ITEM 4.1 (b)

Issue/ Objection:
Car Parking

85 Harrington Street
The Rocks
GOLDEN AGE & HANNAS THE ROCKS

RESPONSE TO DoPE
ITEM 4.1 (b)

title
Plans
Level Basement 1

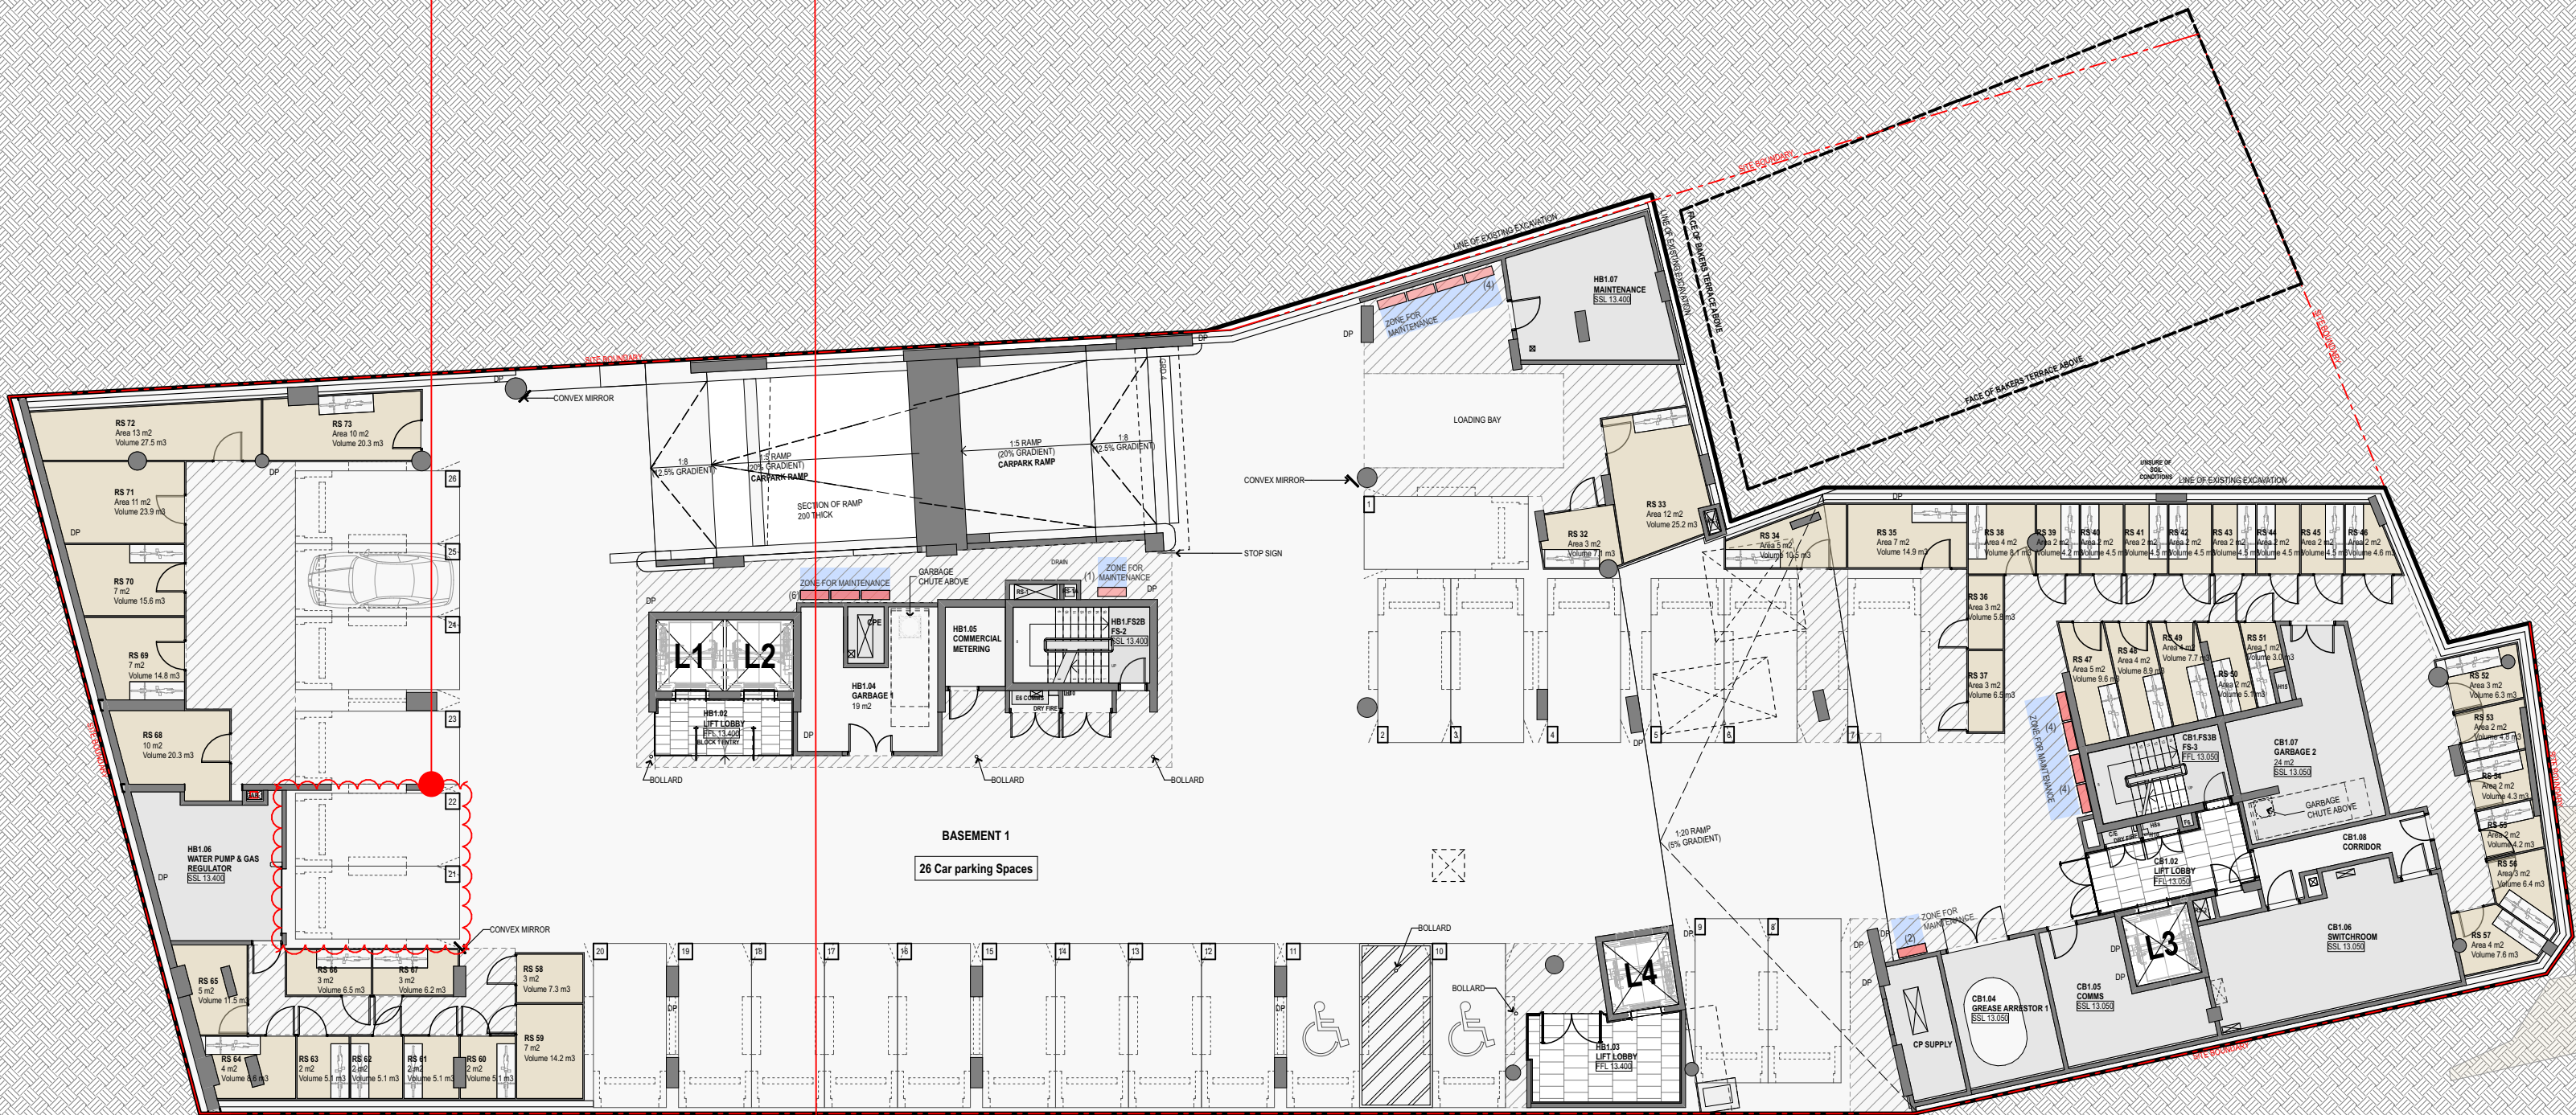
Description:
Given the location of the site within the CBD and close proximity to a variety of public transport nodes, consideration should be given to further rationalisation of the proposed number of residential car parking spaces.

Response
Refer to drawings and report provided by the traffic consultant.
